12 December 2024

Department of Planning, Housing, and Infrastructure  
Locked Bag 5022  
Parramatta NSW 2124

**Inner West Council Response: SSD-73228210 – Mixed use development with affordable housing at 129-153 Parramatta Road and 53-75 Queens Road, Five Dock**

Figure 1: showing proposed design footprint & site tree removal plan

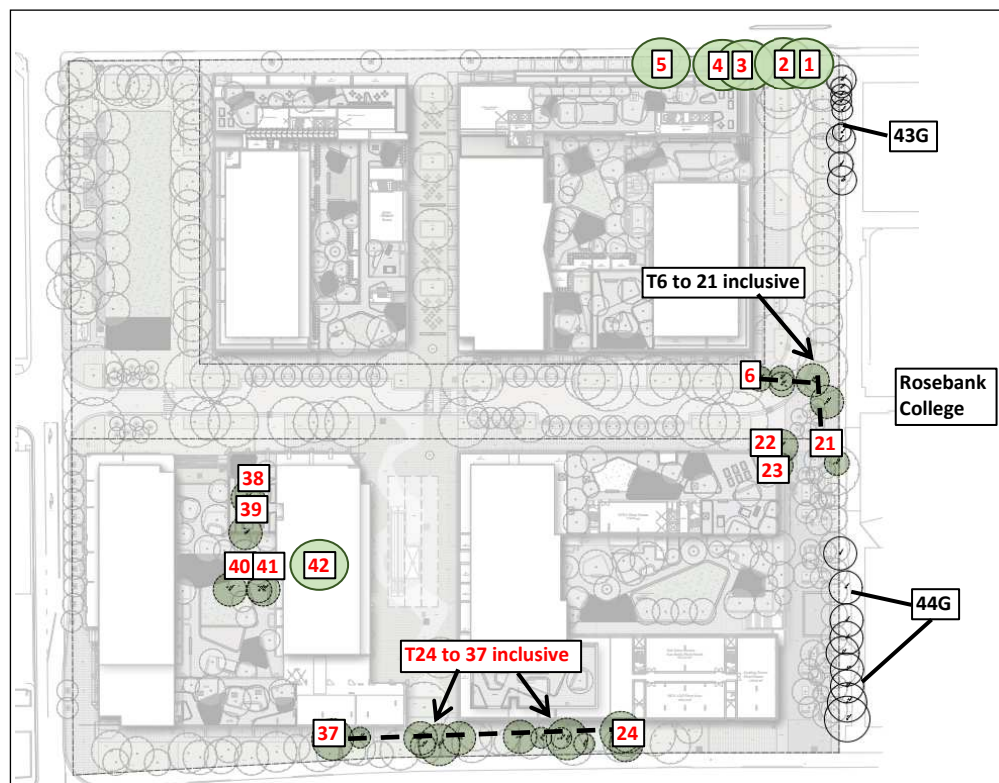
The overshadowing caused by the proposed uplift scheme and the associated variation to the Height of Building Development Standard will reduce solar access to private open space areas and the main living room glazing of the low-density residential dwellings along Lang Street, Dalmar Street and Byron Street during the Winter Solstice. This overshadowing is inconsistent with the DCP's solar access provisions. Specifically, properties from No. 73 to No. 49 Dalmar Street and No. 2A Lang Street will be overshadowed from midday onward and properties from No. 34 to 42 Byron Street will be overshadowed at 3pm, creating adverse solar access impacts.

Considering the above, Inner West Council recommends the built form of the proposed mixed-use development is designed in consideration of the solar amenity of the low-density residential dwellings within Croydon. Specifically, it is recommended that the height of the buildings is reduced to ensure compliance with the Height of Building Development Standard.
